Cherwell District Council

Lead Member Report for Lead Member for Planning

<p>Amendments to Graven Hill Phase 1 Local Development Order</p>

**APPENDIX A: Graven Hill Phase 1 Local Development
Order (Revision) 2016**

Schedule 1 – Land to which this Order applies

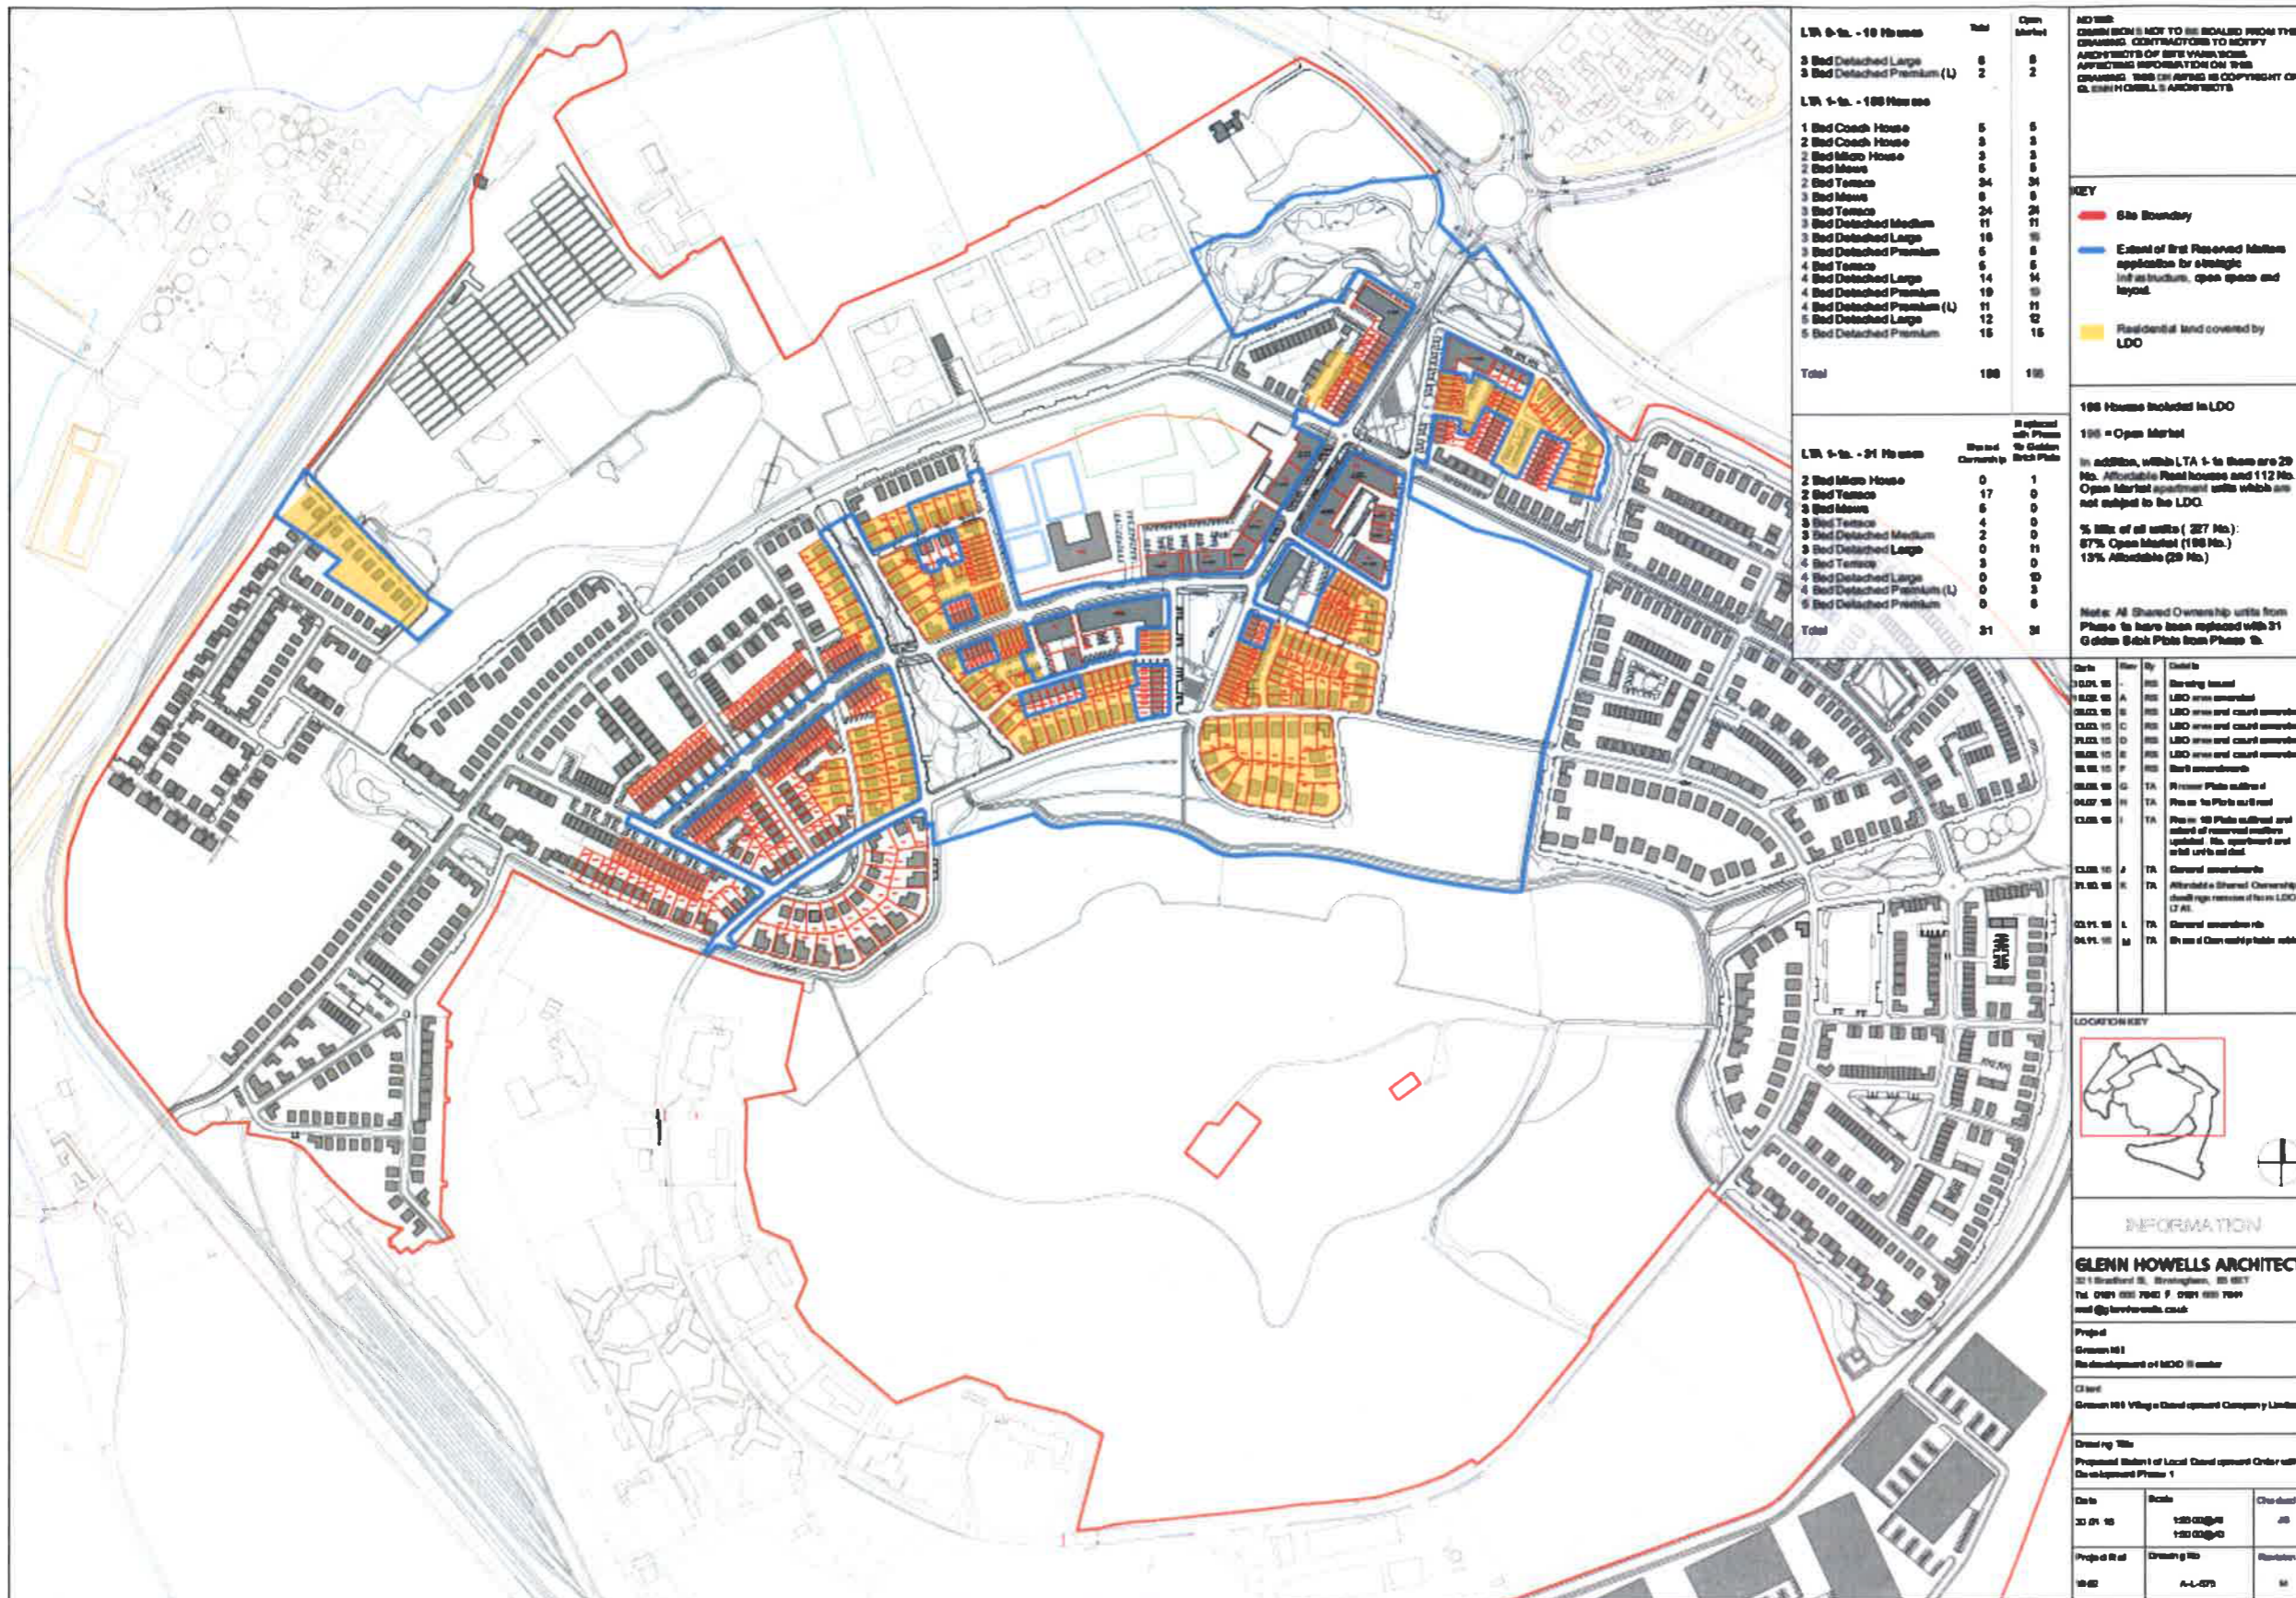
- 3.4 A new plan to show the land to which the Order applies. The amended plan has removed the 31 shared ownership terraces (17no. 2 bed terraces, 3no. 3 bed mews, 4no. 3 bed terraces, 2no. 3 bed detached and 3no. 4 bed detached) from the LDO and replaced them with 31 standard selfbuild plots (1no. 2 bed micro house, 11no. 3 bed detached, 13no. 4 bedroom detached and 6no. 5 bedroom detached).

(3) This Order applies to the land at Graven Hill Bicester shaded Yellow and annotated as "Residential land covered by LDO" on the plan included as Schedule 1 to the Order.
